From: Anita Gardner
Sent: 04 July 2017 09:31
To: Karen Parsons
Subject: FW: AB/40/17/L Provision of first floor window

From: Anita Gardner
Sent: 26 June 2017 14:28
To: [REDACTED]
Subject: AB/40/17/L Provision of first floor window

I refer to the above application and can advise that I have now received the comments of Dr Wightman, the Historic Building Adviser. He considers the principle of an additional window is fine, but has concerns that the design as submitted is not sympathetic. It is far too modern in character.

DRAWING TITLE
EXISTING & PROPOSED
ELEVATIONS

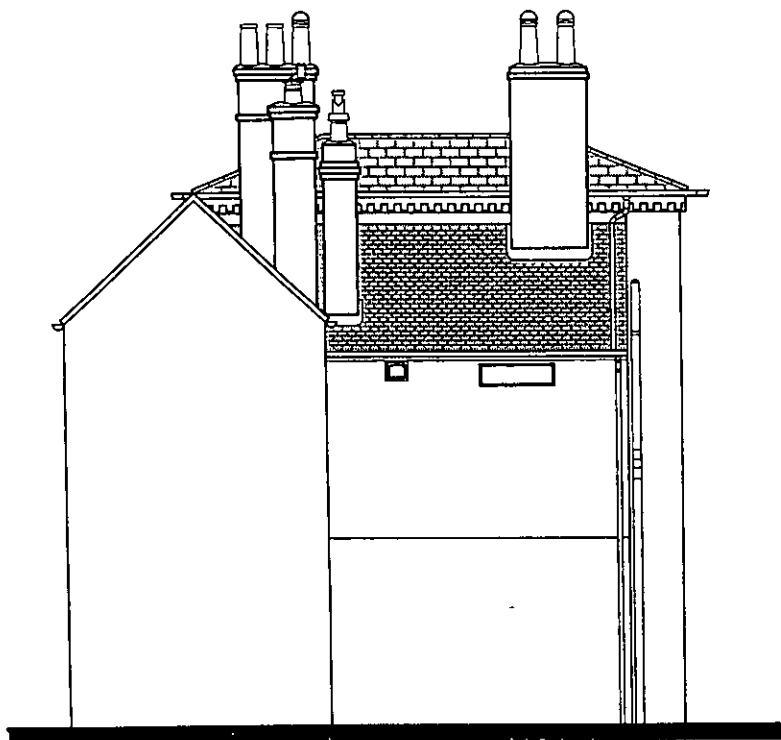
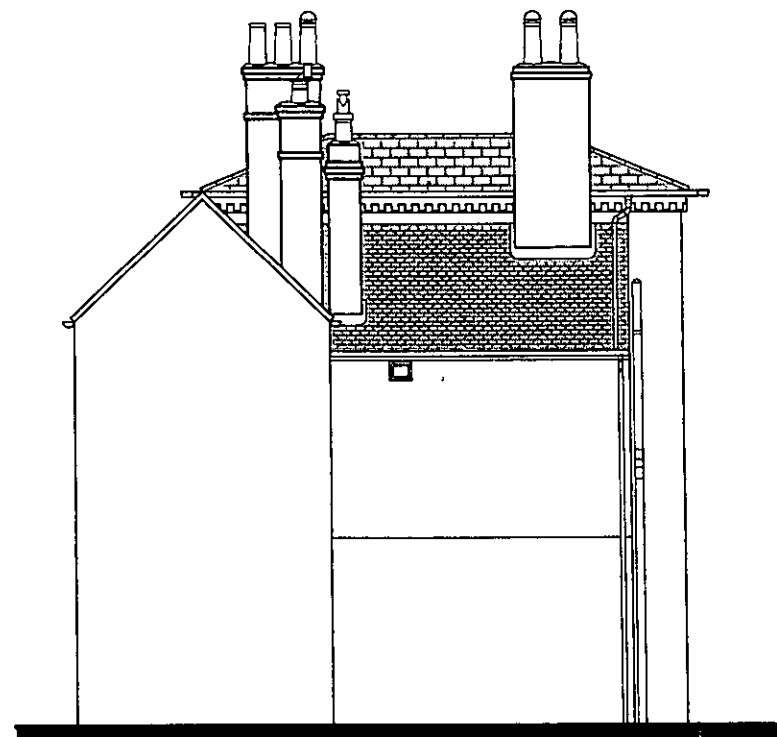
Without prejudice, I would therefore appreciate receipt of a revised elevation plan to indicate an opening of more appropriate design within the next 2 weeks. I would also be grateful if you could agree to an extension of time on the application, to allow time for receipt of plans and re-consultation, of one month until 26-07-2017 to facilitate this.
